Comments on the Deadline 2 Submissions

This document sets out the comments by Cambridgeshire County Council (**CCC**) on Deadline 2 (**D2**) submissions. The tables below set out the document in question that the Council is commenting on, together with the relevant paragraph or reference number.

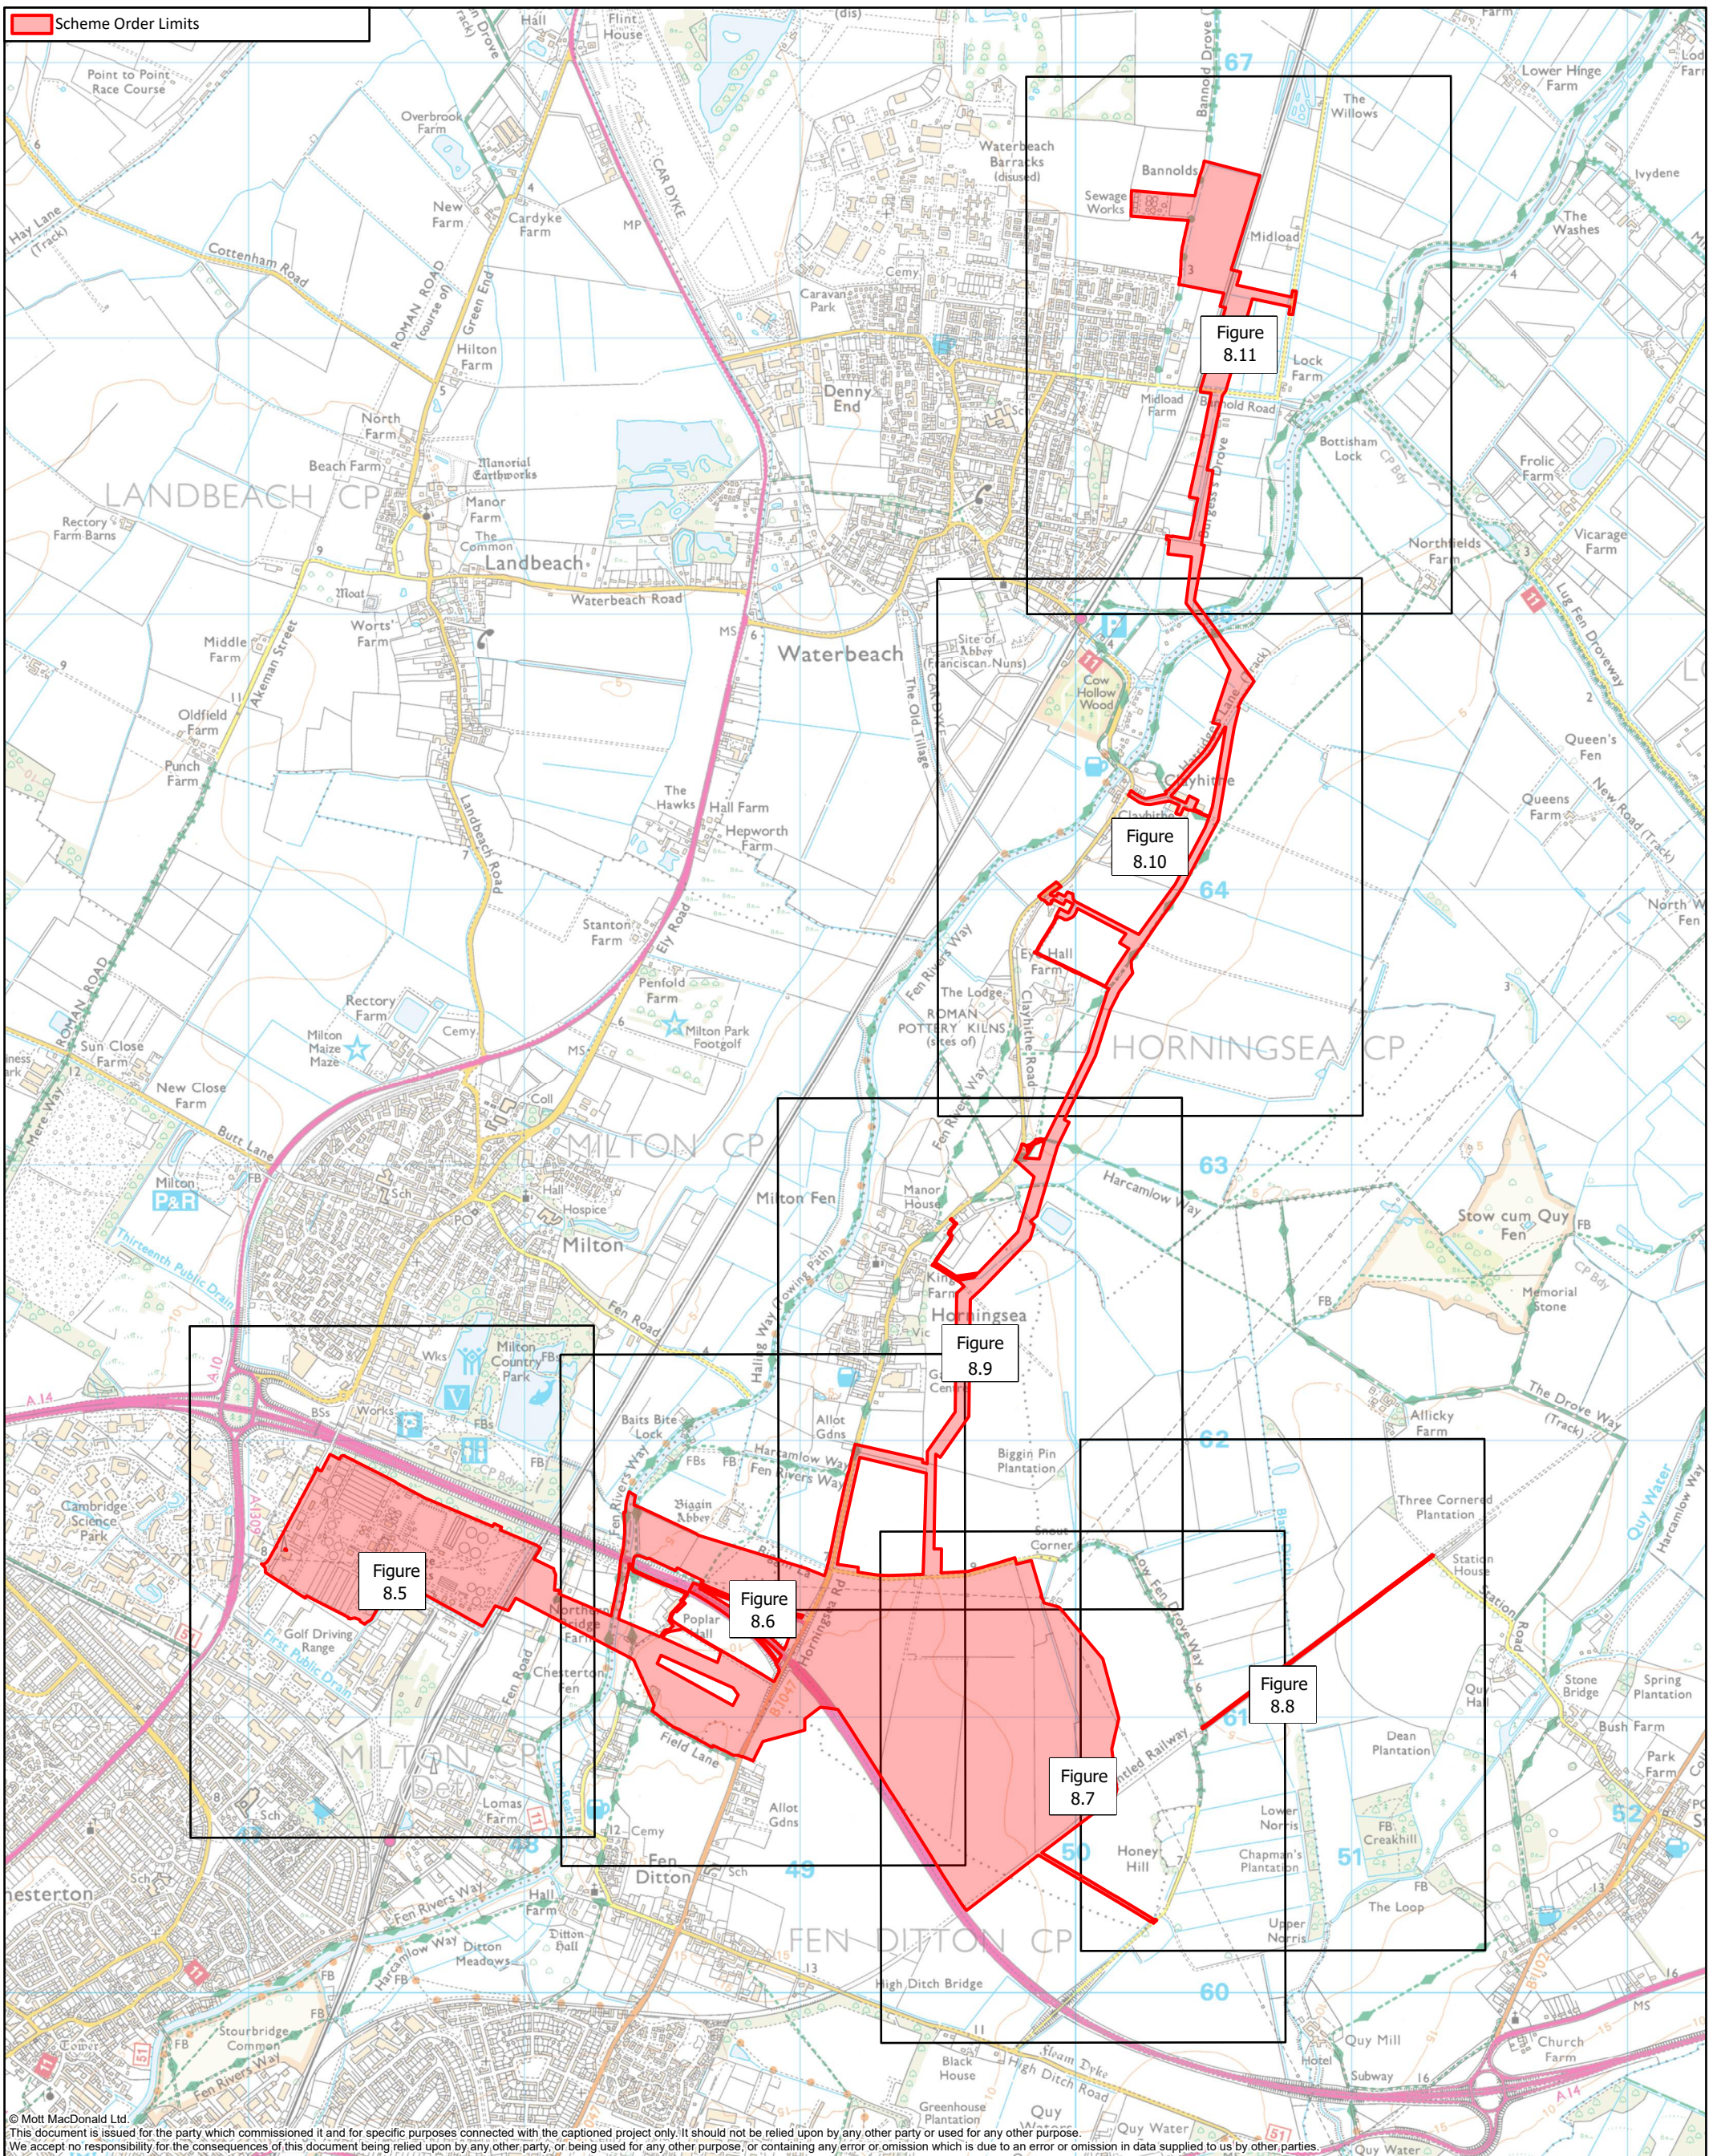
Topic	Paragraph Number	Councils' Comment
Ancient woodland and veteran trees	3.1.13	It is unclear why veteran oaks, referenced within paragraph 3.1.13, are not given further consideration or assessment as part of the ES Chapter 8 Biodiversity. Particularly given that Figure 8.3, Chapter 8 Book of Figures Biodiversity [REP2-019] states the following mitigation: " <i>impacts avoided by micro-siting of Waterbeach pipeline away from tree</i> ".

Topic	Paragraph Number	Councils' Comment
		The Council is unclear what Figures have been updated, given that no tracked changes / explanatory text has been included to explain differences with previous submissions.
Veteran oak trees	Figure 8.3	It is noted that the drawing has been updated to confirm “ <i>Veteran Oak - impacts avoided by micro-siting of Waterbeach pipeline away from tree</i> ” for both veteran oaks.
